**CITY OF ALBUQUERQUE
PLANNING DEPARTMENT
January 27, 2016
DRB Comments**

PROJECT # 1010728

APPLICATION # 16-70020

RE: Lots 8 & 9, Houston Addition

# SKETCH PLAT

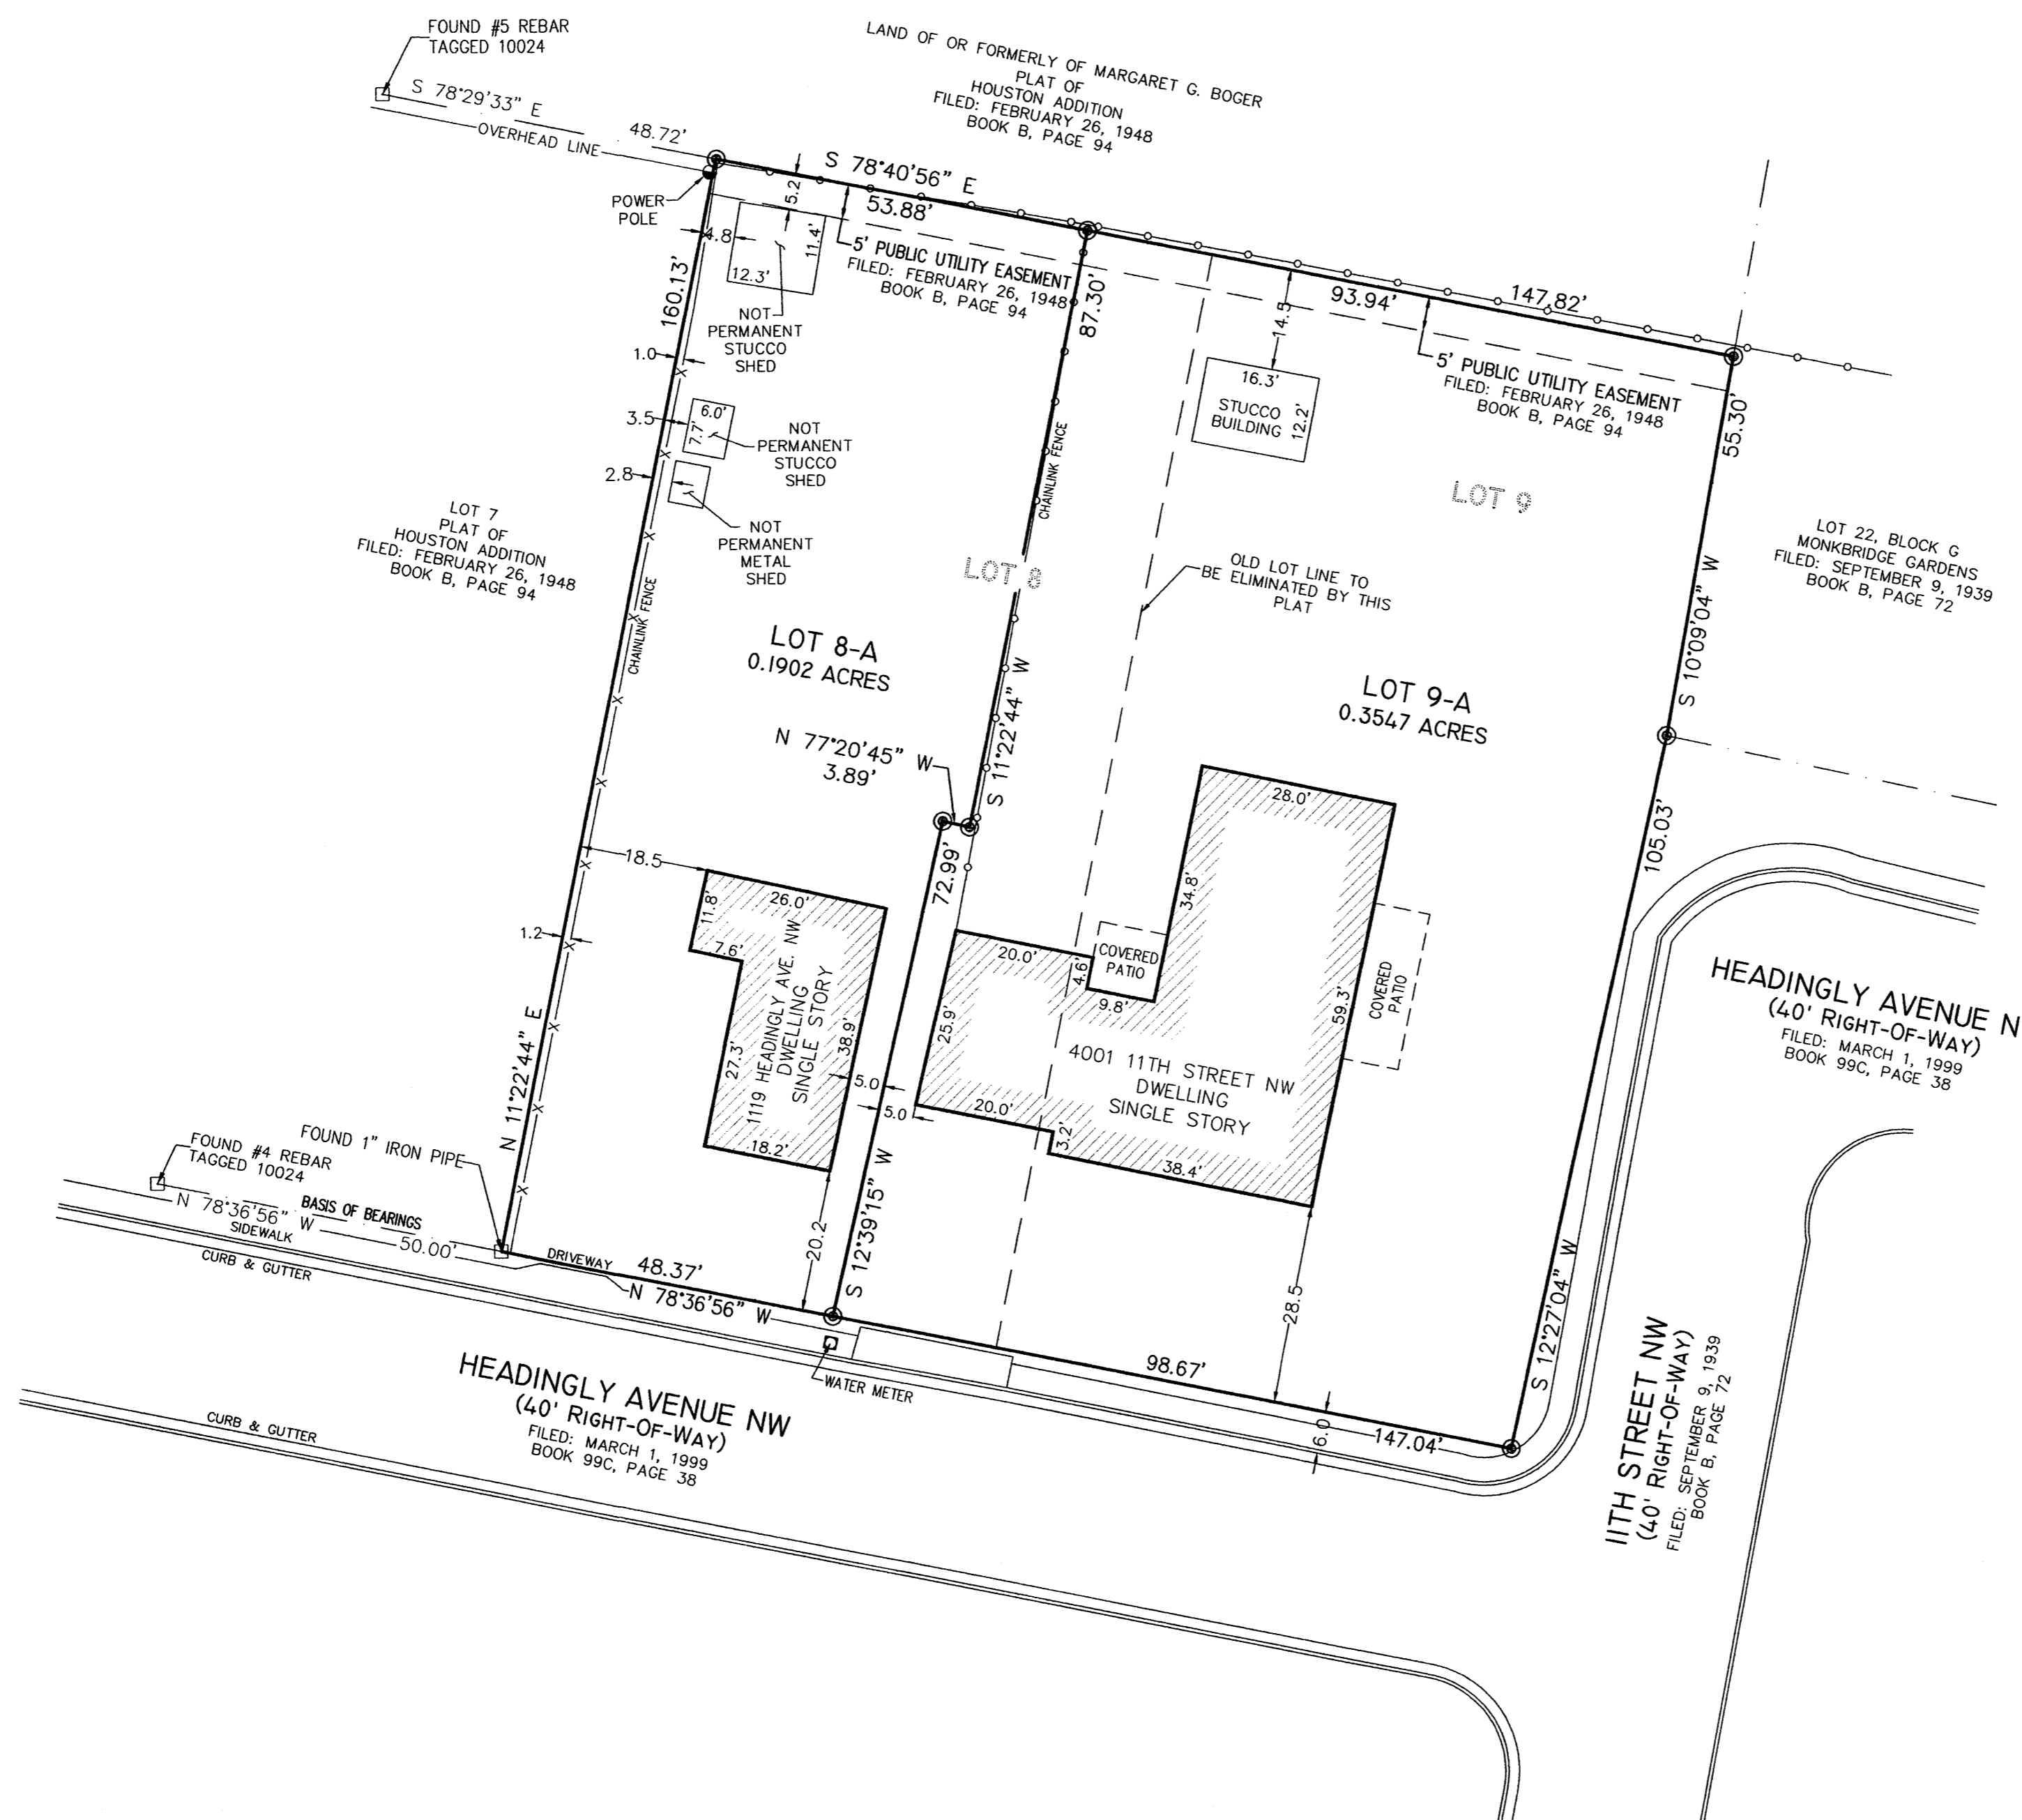
There appears to be a pilaster and steel rail fence that would encroach into proposed Lot 9-A; this needs to be moved, removed, or a Fence and Use Easement needs to be provided.
